Our ref: OR-0005267/01
Your ref: EN010168
Interested Party ref: [REDACTED]
Date: 15 June 2026

Lime Down Solar Park – Development Consent Order (DCO) Application

Environment Agency Examination Deadline 3 Response: Comments on documents submitted at Deadline 2 and Examining Authority’s First Written Questions

Fig 1: Area D in relation to EA flood zones. Pinkish areas in numbered fields are solar panels. Green areas are substations, orange, the BESS. EA Flood Zone 3 (>1% AEP) is shown in dark blue; Flood Zone 2 (0.1 to 1% AEP) in light blue; remaining areas are Flood Zone 1 (<0.1% AEP)

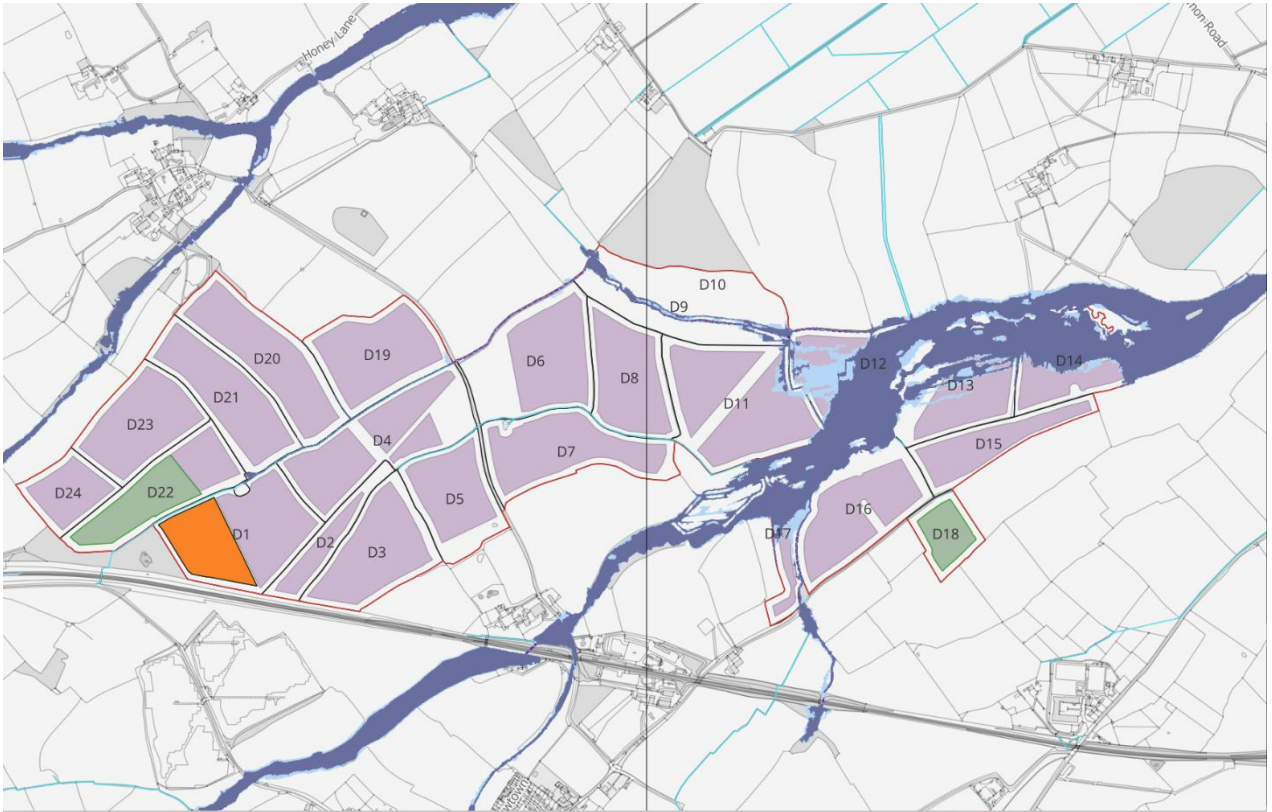
ExQ1	Question to:	Question:	Environment Agency Response
		<p>the applicant for Lime Down D and E2.</p> <p>2) The EA is asked to explain if the information submitted by SLD, specifically in document [REP1-176] could support an extension to Flood Zone 3b in Lime Down D and if so, to which fields.</p> <p><u>The Applicant:</u></p> <p>3) The applicant is asked to confirm the freeboard allowances requested by the EA in their document [REP2-049]</p>	<p>Lime Down E2 Modelling</p> <p>With respect to Lime Down E2, we have yet to receive the modelling for this site. We understand the applicant will be sending this to us for review shortly. We will review the modelling and provide comment on its suitability in due course.</p> <p>Sites A, B, C, and E1</p> <p>More widely, sites A, B, C, and E1 are almost entirely within Flood Zone 1. The Flood Map for Planning generally only covers watercourses with a catchment area of greater than three square kilometres. There are several smaller Ordinary Watercourses and drainage ditches which cross these sites which have no associated Flood Zone mapping due to the small size of their respective catchments.</p> <p>In these locations, the applicant has used the Environment Agency's Risk of Flooding from Surface Water (RoFSW) mapping as a proxy for fluvial flood risk. This mapping is derived from direct rainfall hydraulic modelling combined with Light Detection and Ranging (LiDAR) digital terrain model data.</p> <p>Where the RoFSW mapping has been used in this way we have asked the applicant to undertake checks to ensure that this dataset is representative or conservative in the context of fluvial flood risk and informing the design flood level for the development. The applicant has used the Manning's equation to explore how water levels within the smaller Ordinary Watercourses might respond to increasing flows</p>

ExQ1	Question to:	Question:	Environment Agency Response
			<p>and has placed this in context with water levels estimated from the RoFSW data.</p> <p>The application of the Manning’s equation in this context has some limitations. Firstly, the cross sections have been derived from Lidar data rather than channel survey. Lidar tends to underestimate channel depth. Additionally, the Mannings equation assumes a depth averaged and spatially uniform velocity across the cross section, which is unlikely to be the case, particularly in the context of floodplain flow. The Mannings calculation does provide some useful information particularly regarding the relative change in water levels with increasing flow which can be useful when trying to understand the risk to solar PV infrastructure.</p> <p>This analysis indicates that water levels within these smaller Ordinary Watercourses are relatively insensitive to increases in flow. On this basis, the use of RoFSW mapping is considered to provide a reasonable proxy for understanding the fluvial flood risk to the proposed development from these smaller Ordinary Watercourses which are not covered by the Flood Map for Planning.</p> <p>In terms of any loss of floodplain storage from the development, the applicant has provided sufficient evidence to demonstrate that this would be negligible in the context of the Gauze Brook and Gabriels Well/ Robbourn Brook and hence has not undertaken “with development” hydraulic modelling for the purposes of quantifying the impact from a loss of floodplain storage.</p>
